SCHEDULE OF PLANNING REVISIONS FOR NMA

PROJECT **higgi haus - 57-59 St Mary's Street Cardiff**
 ISSUE DATE **18/12/2023**
 REVISION

HH ST GA 300

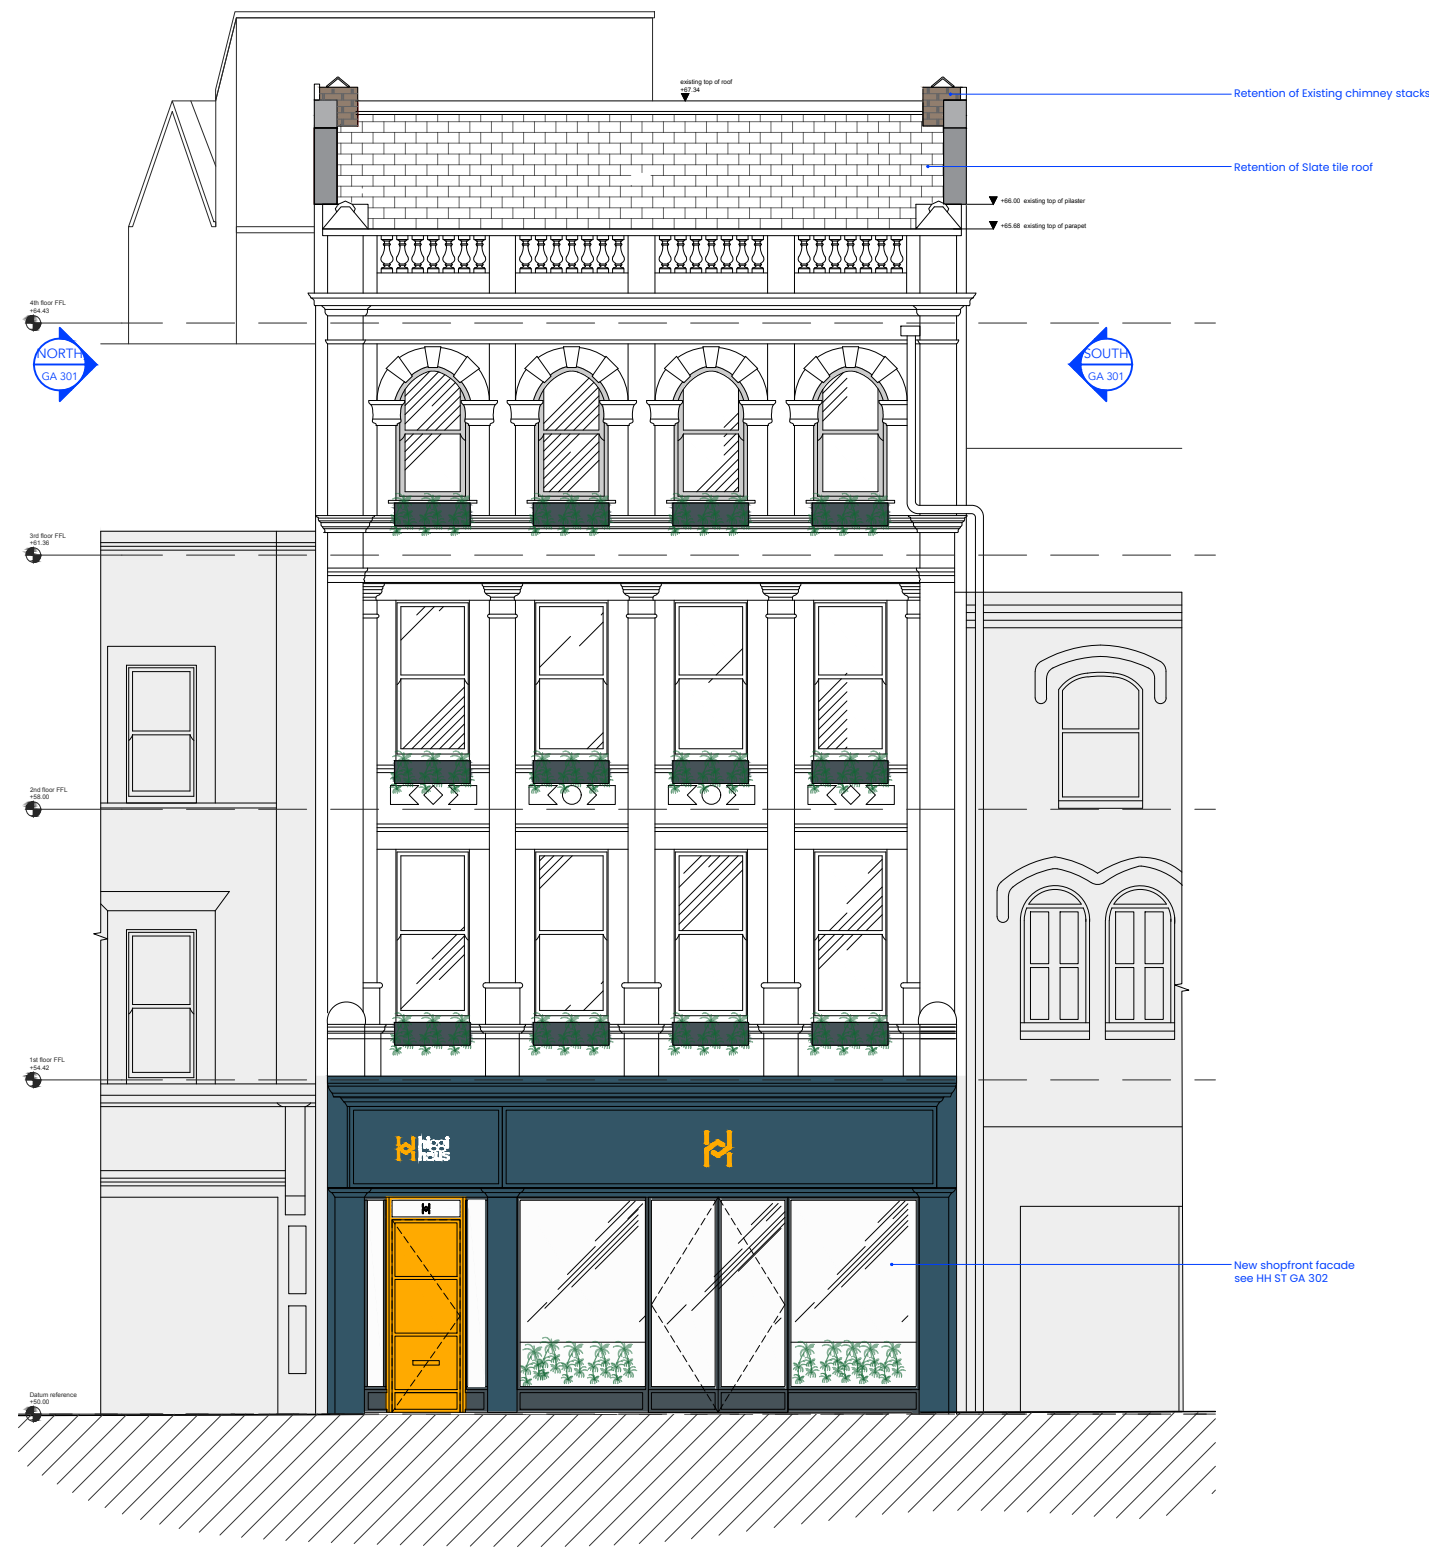
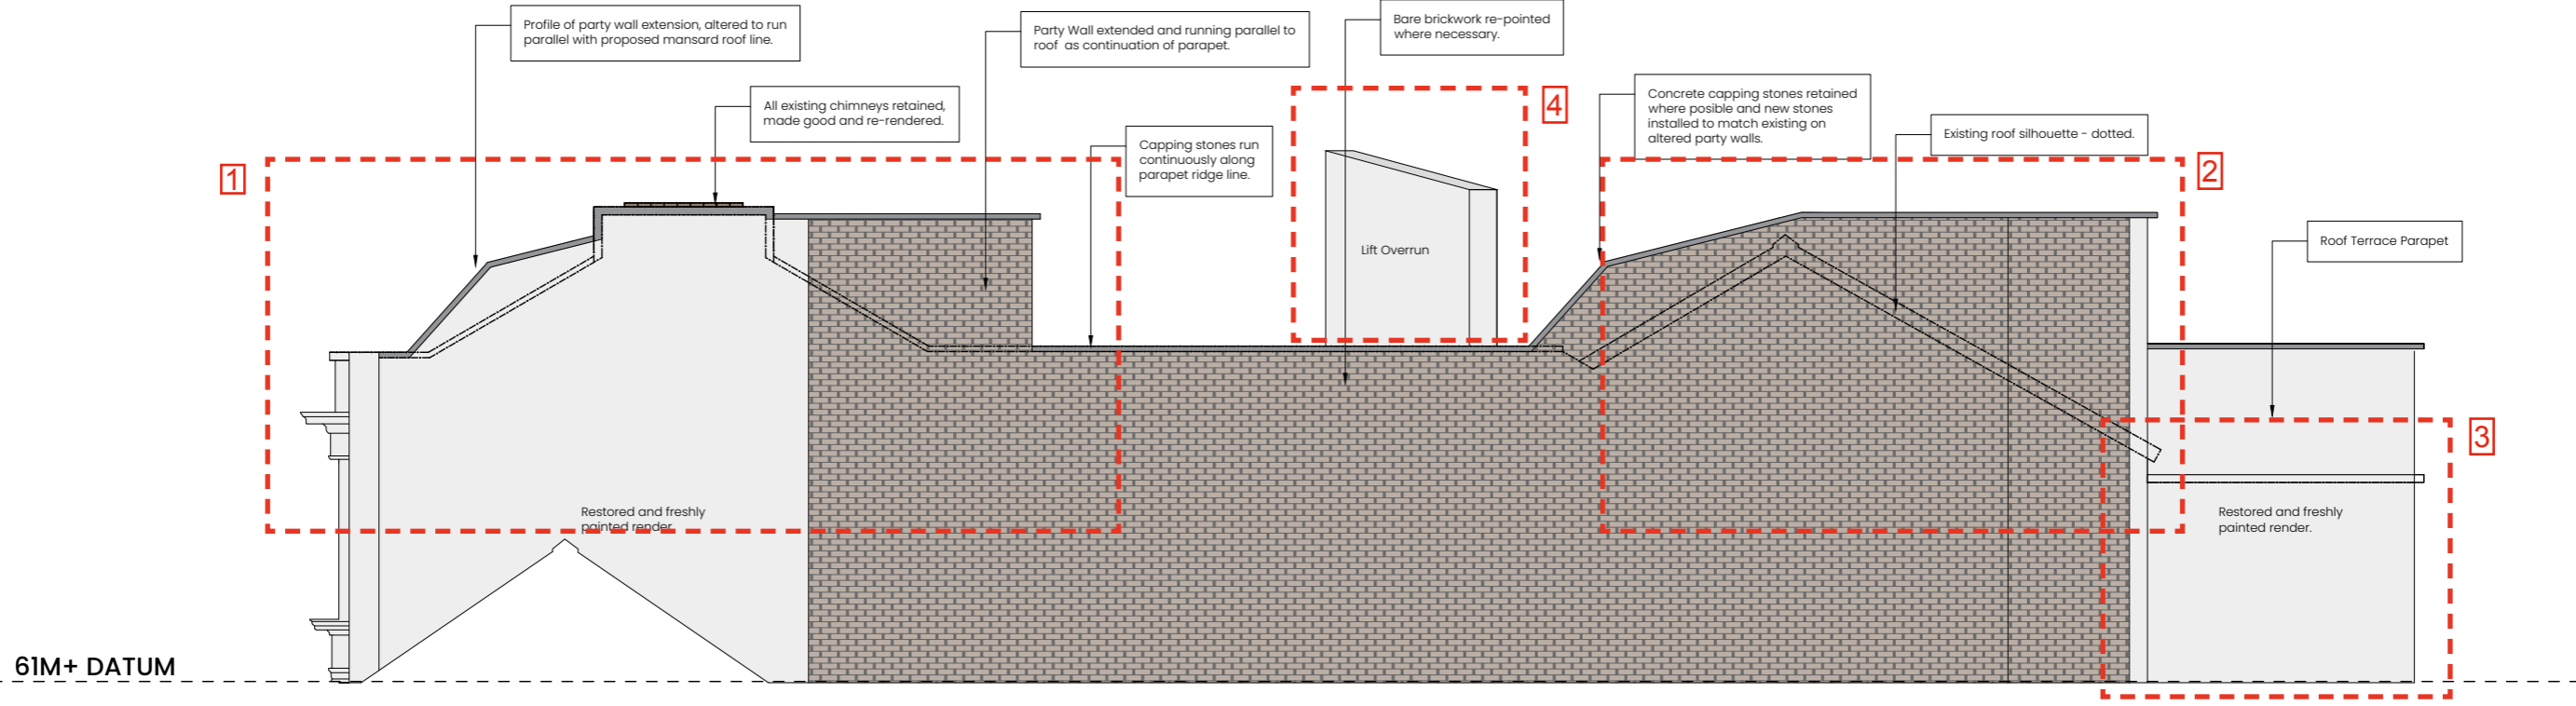
(above drawing removed > elevation details moved to HH ST GA 300)				3	Split shopfront fascia with painted moldings

4	Removing of proposed mansard windows
							5	Removing of proposed new roof mansard (maintaining existing pitched slate tile roof)

PROPOSED SHOP FRONT ELEVATION

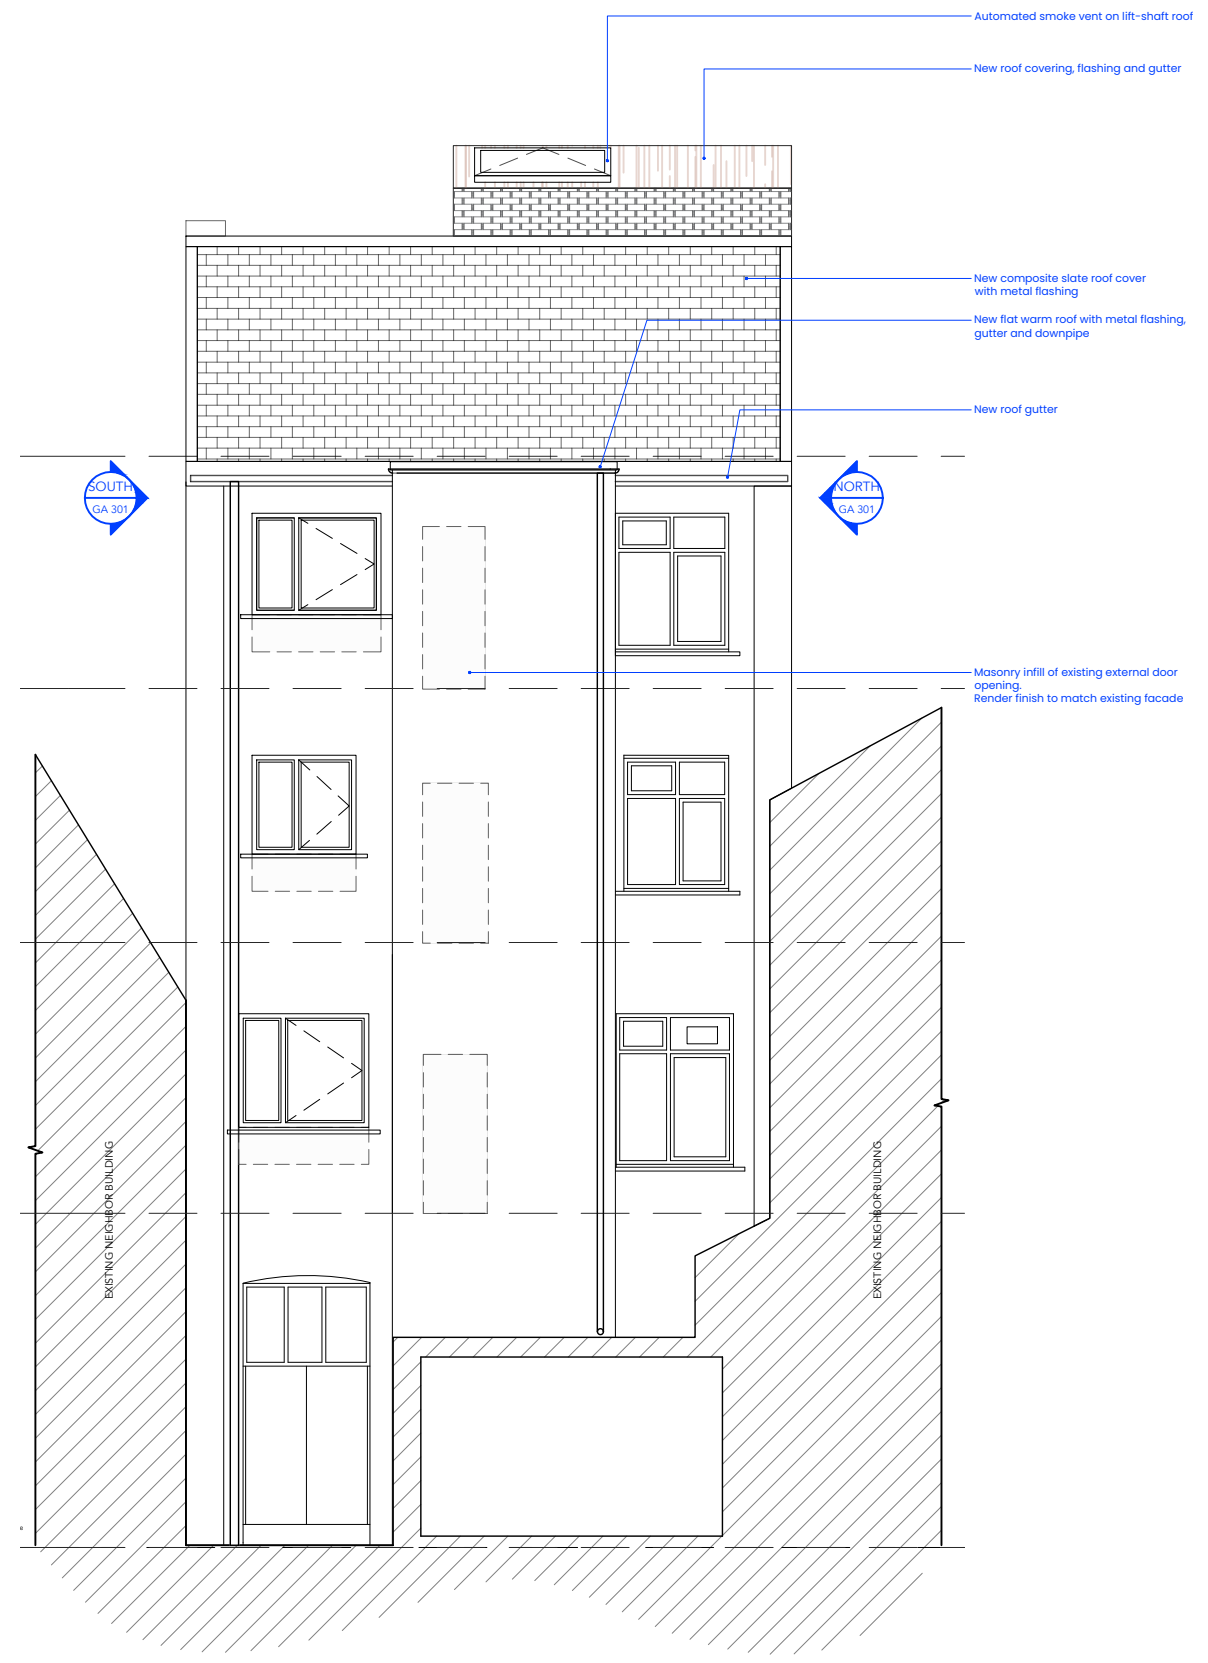
Page 08	JHHSMS/016/P1	Proposed Shopfront Elevation	PI 04.04.22 Planning Application Issue	HH ST GA 302	SHOP FRONT AND ENTRANCE PROPOSED ELEVATION	NMA Issue 12/12/23	1	Added timber faced pillaster to match rythme of split front fascia above
							2	Relocation of co-working space entrance for seperated residential entrance + Reinstatement of a central double galzed door to shopfront façade
							3	Split shopfront fascia with painted moldings

PROPOSED GA ELEVATION - SOUTH

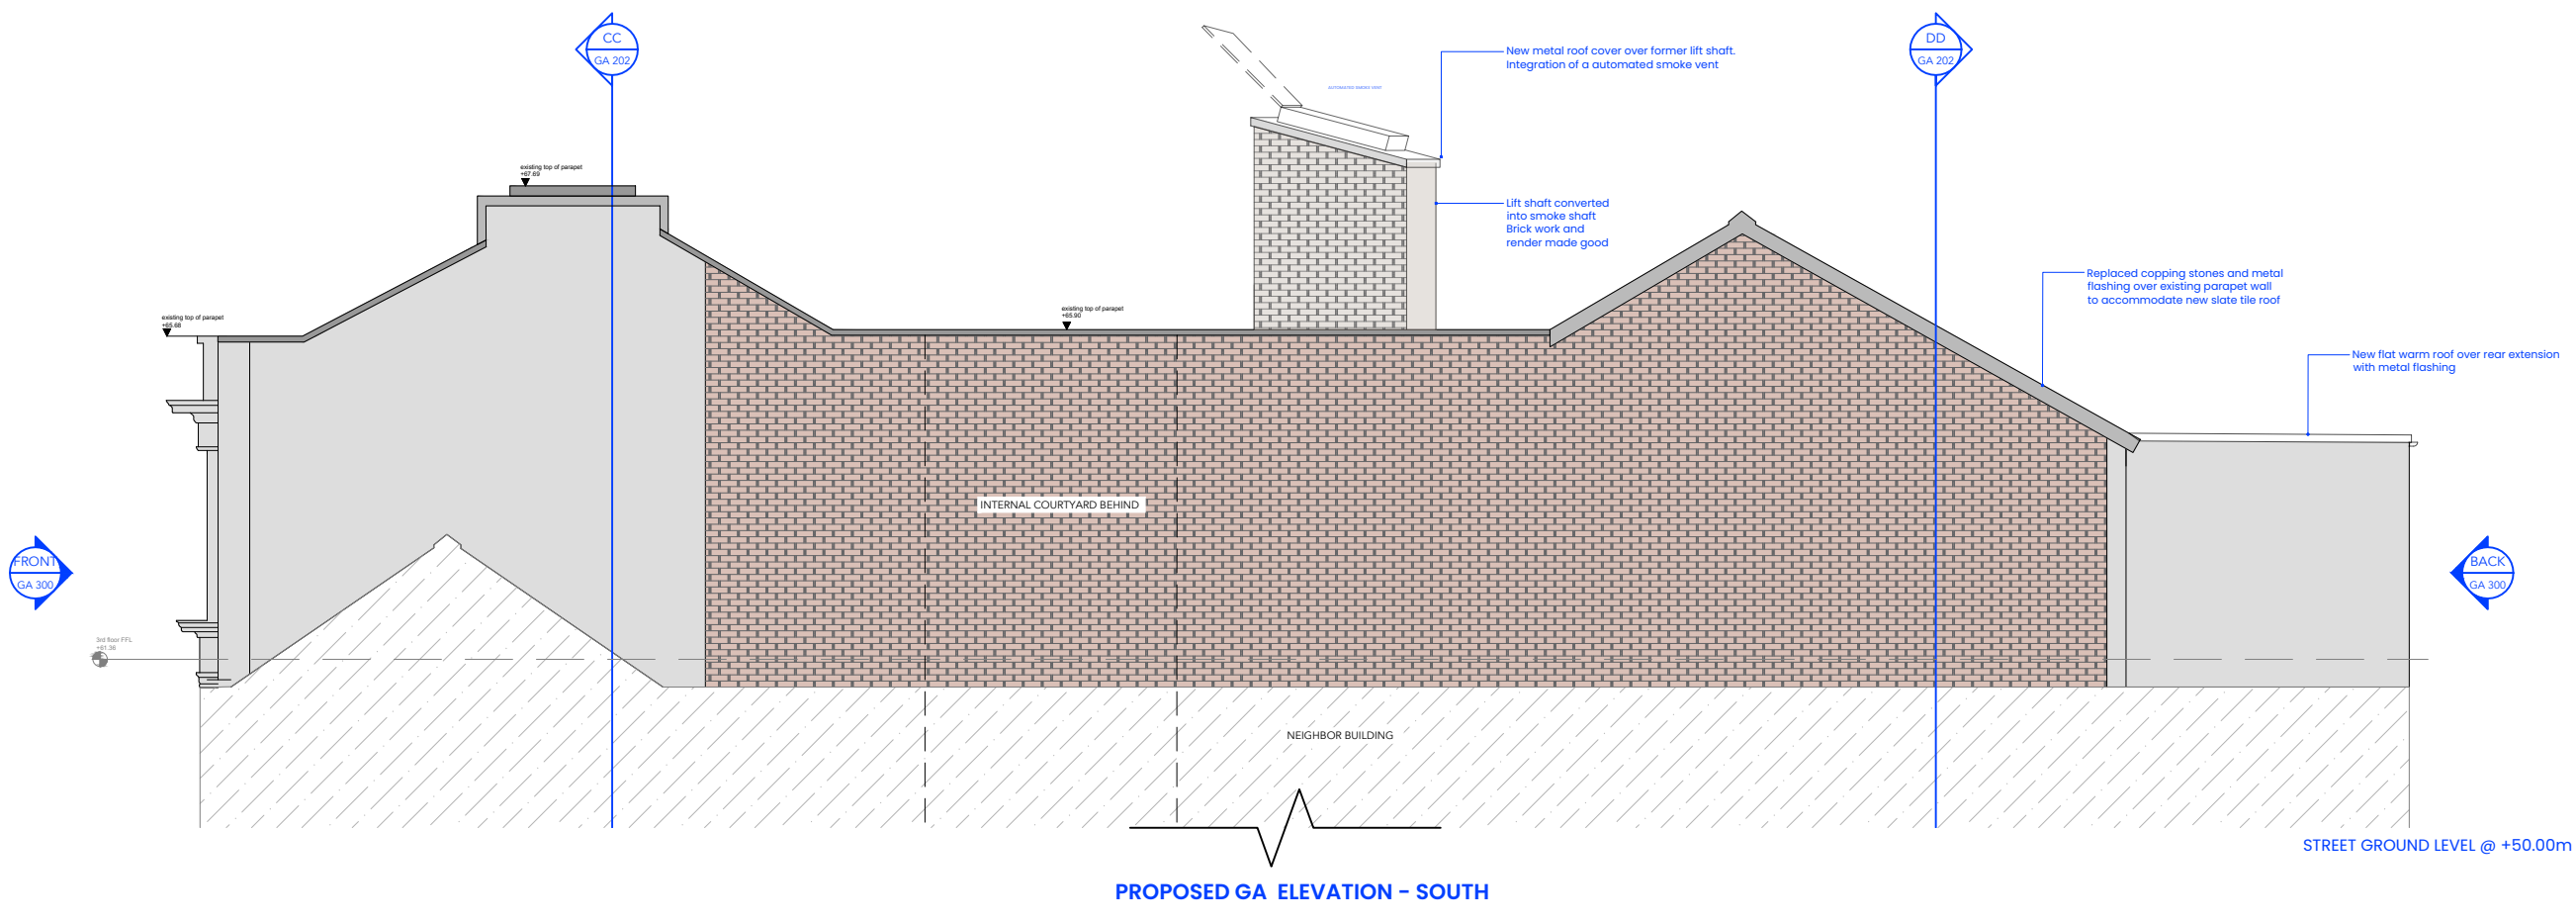
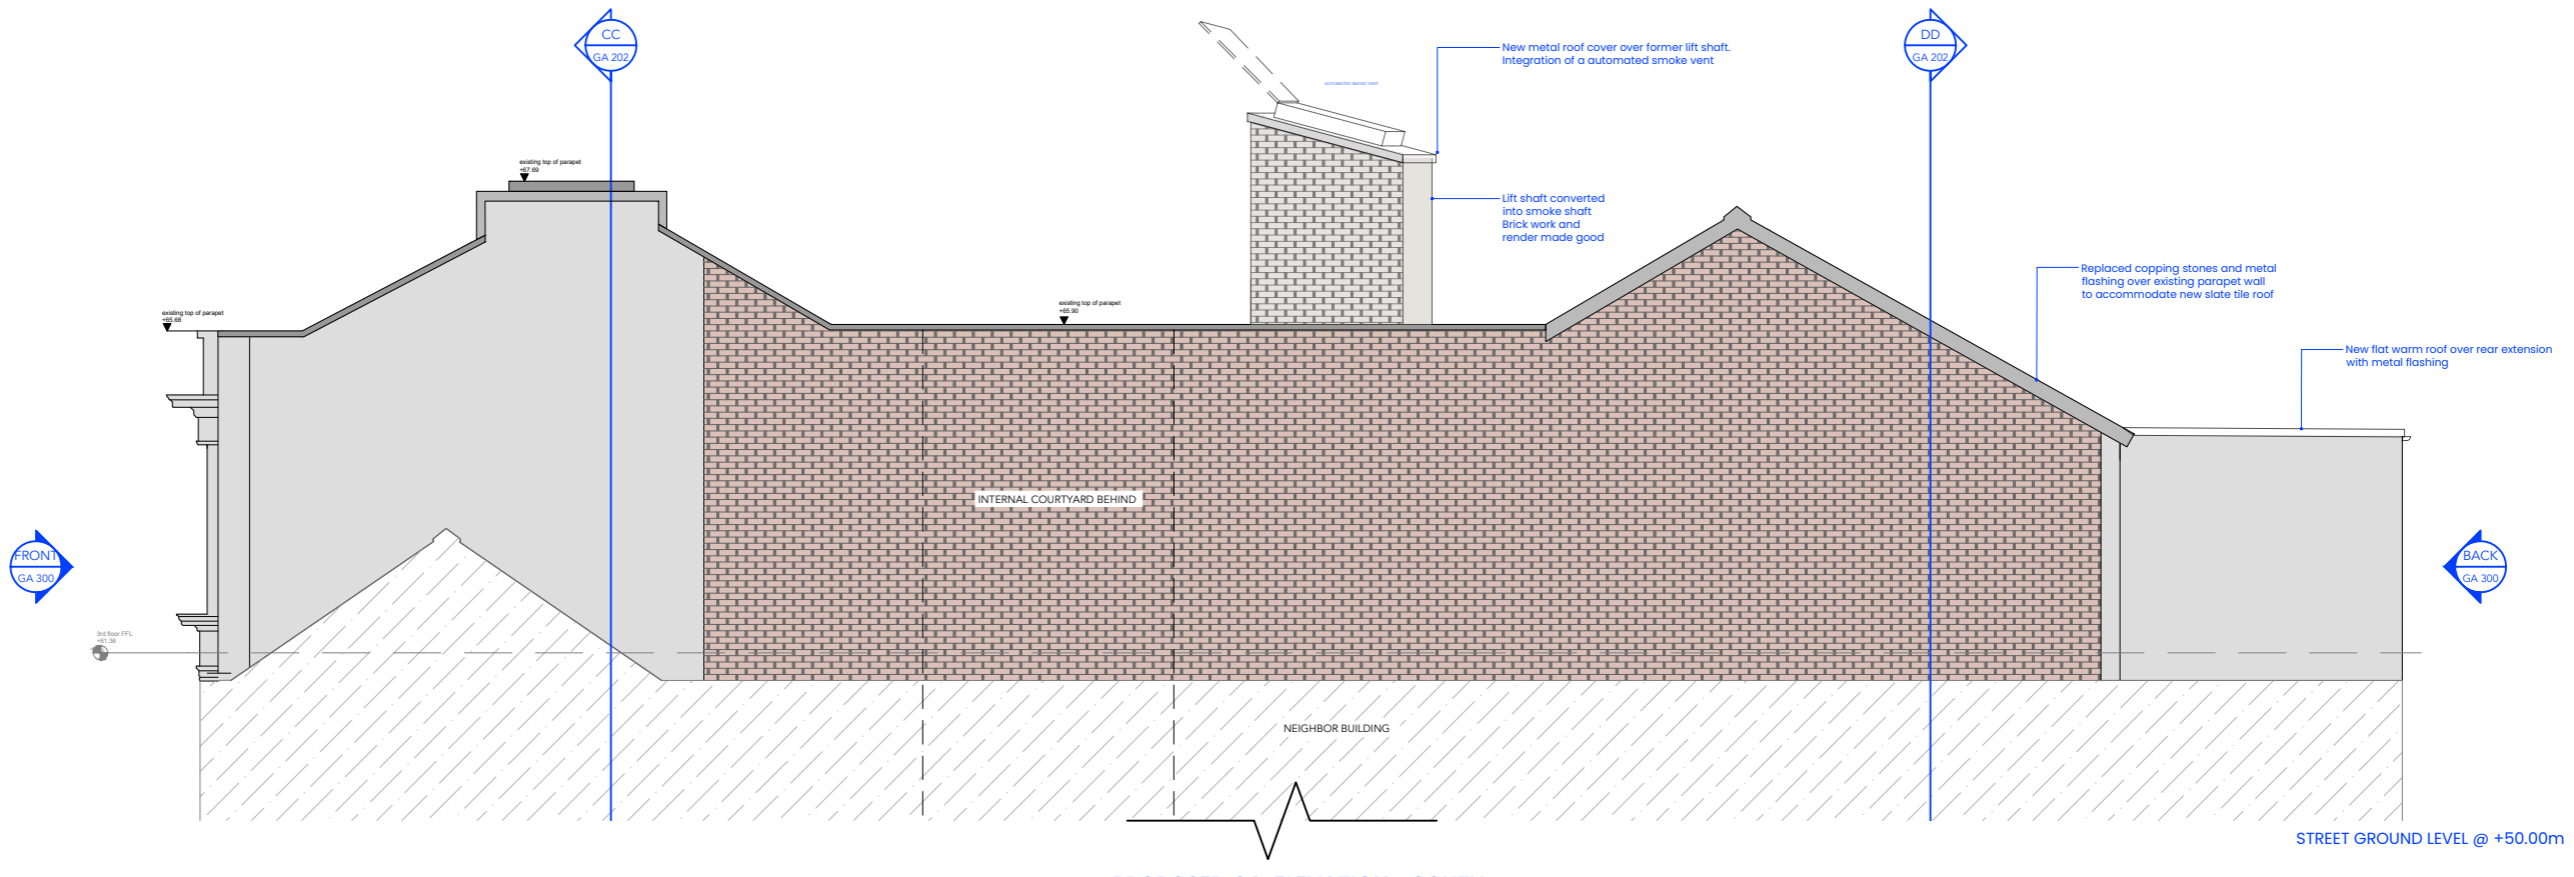
Page 09	JHHSMS/019/P1	Existing & Proposed South Elevation	PI 04.04.22 Planning Application Issue	HH ST GA 301	SOUTH AND NORTH ELEVATIONS GA PROPOSED	NMA Issue 12/12/23	1	Removed proposed mansard roof extension
							2	Removed proposed mansard roof extension - Replacing of existing corrugated roof cover for slate tiles
							3	Removed roof and parapet extension Replaced coping stones and waterproofing
							4	Replacing of the existing corrugated roof over former liftshaft over run for the integration of a automated smoke vent
